## Appeal Decision

**Appeal Ref: APP/R4408/D/23/3318802**

**3 Hall Place, Monk Bretton, Barnsley S71 2EX**

**PROPOSED RIGHT HAND SIDE ELEVATION.**

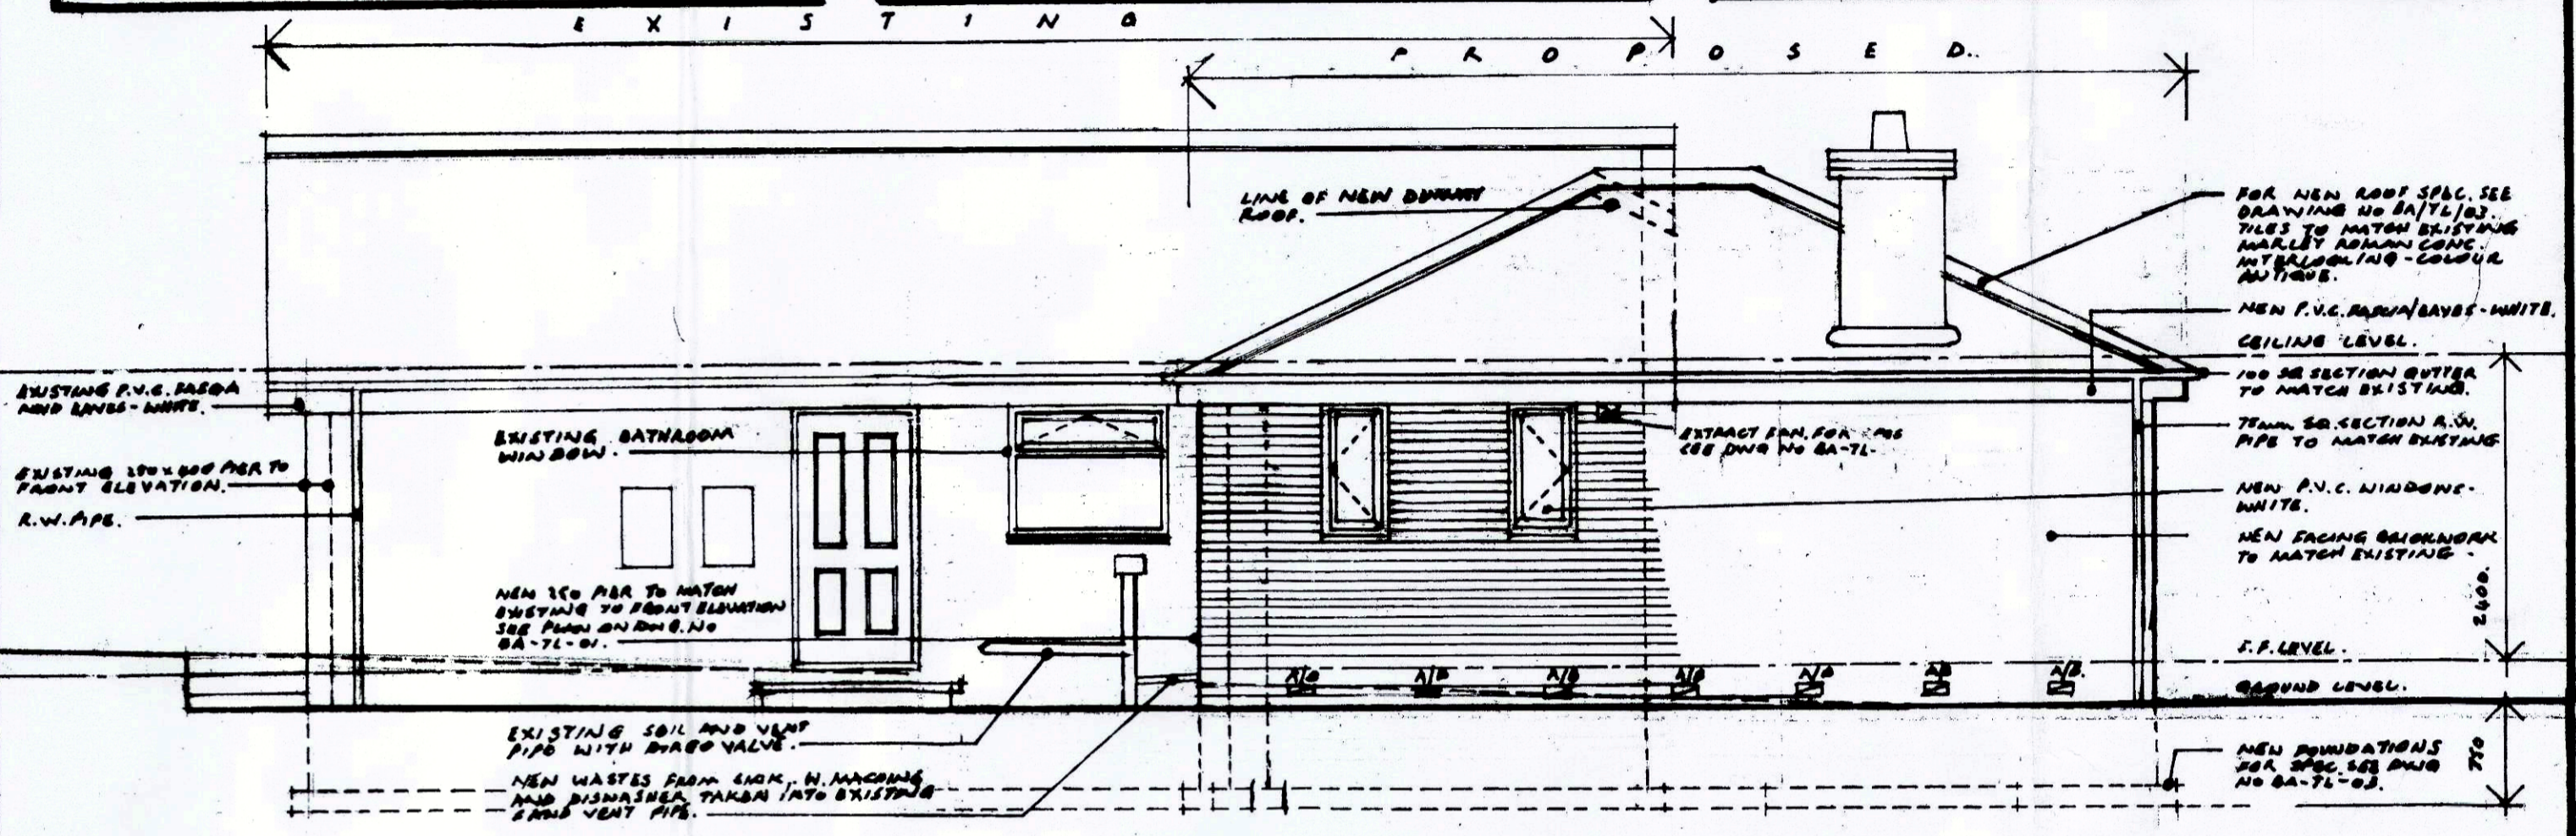
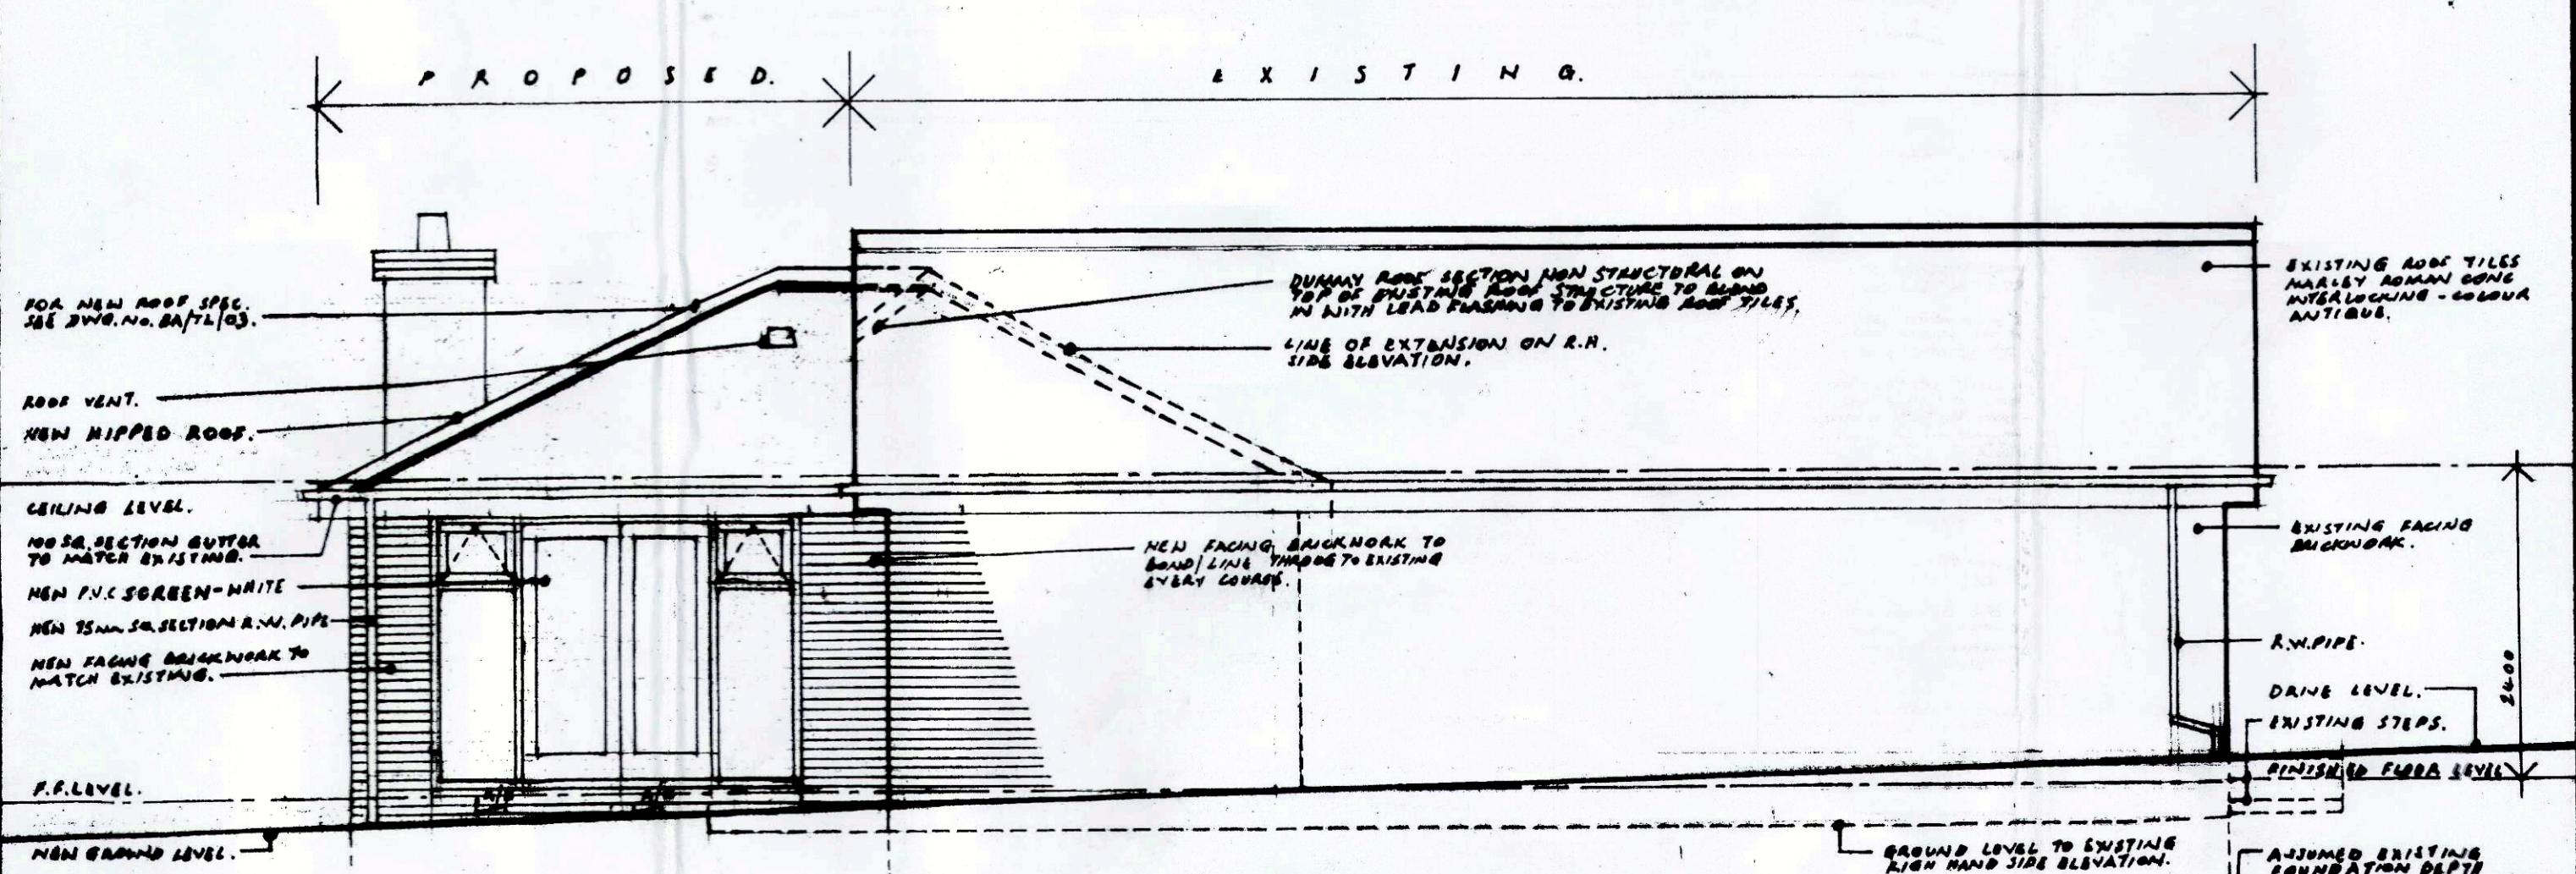
roof plane of the new single storey rear/side extension is a chimney stack that provides extract from a fireplace in the lounge. The chimney stack is brick built, around 0.8m in depth and is a height of around 1.5m from the roof plane (or 1.6m including the flue).

6. Although higher than the ridge of the host bungalow and prominent on the corner as you enter Hall Place from Cross Street, I did not find the chimney to be a particularly incongruous feature or excessive relative to the significant scale of the extended roof of the bungalow. The chimney stack has a functional appearance, but this does not equate to poor design, and the use of brick means it assimilates with its host. Further, I did not find the chimney stack to be out of keeping with the surrounding area and streetscene, which I observed on my site visit is characterised by a mix of dwelling types and styles, and includes chimney stacks of various sizes and design.

7. Irrespective of whether the dimensions of the chimney are a requirement of Building Regulations, I conclude that the chimney stack causes no harm to the character and appearance of the host bungalow or the wider streetscene. It does not therefore conflict with Policy D1 of the Barnsley Local Plan (2019) or paragraph 130 of the National Planning Policy Framework which both expect development to be of high quality design that respects, or is sympathetic to, local character.

1. The appeal is allowed and planning permission is granted for erection of single storey side/rear extension and erection of chimney stack positioned on roof plane of the extension at 3 Hall Place, Monk Bretton, Barnsley S71 2EX in accordance with the terms of the application, 2022/0937, dated 6 July 2022, and the plans submitted with it, subject to the following conditions:
  - 1) The development hereby permitted shall be carried out in accordance with the following approved plans: Site Plan, Location Plan, Elevations (Revision B); and Floor Plans and Elevations (Revision C).
